Ref: 6/2021/2816/HOUSE
Date: 23/12/2021

HISTORIC BUILDINGS AND CONSERVATION ADVICE

RE: 53 High Road, Essendon, Hatfield, AL9 6HS

The application is for extension of existing dropped curb.

PROPOSED PLAN WITH EXTENDED
DROPPED KERB & BUSH REMOVAL

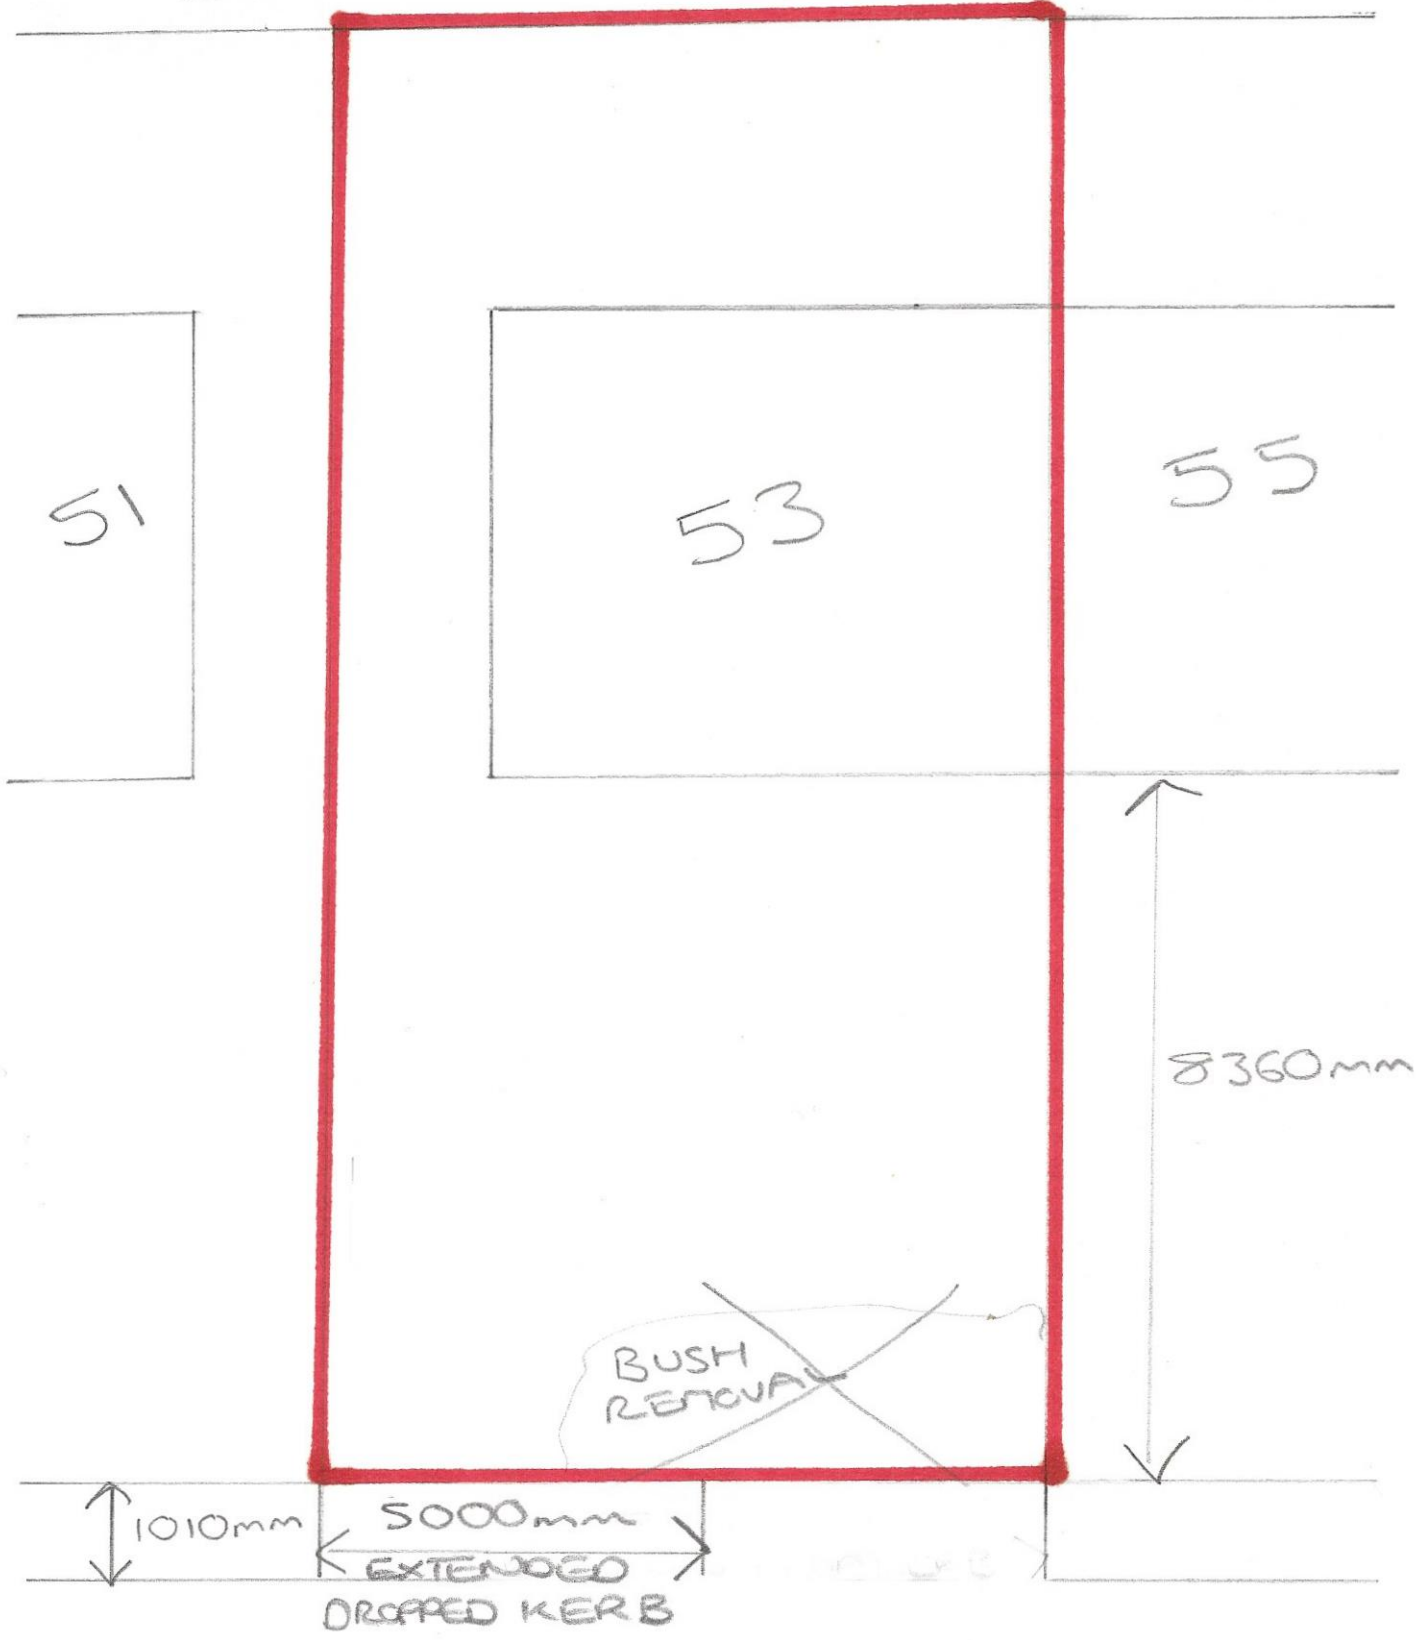
Whilst there is no objection to the extension of the dropped kerb itself, there is an objection to the loss of the hedge and the dwarf rendered wall along the front boundary. This traditional boundary treatment, particularly the hedge, contributes to the character of this part of the Conservation Area and the verdant appearance of the streetscene on entering the historic core of the village from the south.

If a greater extent of the hedge were to be retained and meaningful replacement planting proposed within the front garden space then the concerns may be addressed. However, as proposed, the loss of the hedge and boundary wall is considered to result in some 'less than substantial' harm to the significance of the Conservation Area and paragraph 202 of the NPPF should be applied. The proposal is not considered to preserve or enhance the character or appearance of the Conservation Area, as per Section 72 (1) of the Planning (Listed Buildings and Conservation Areas) Act 1990.
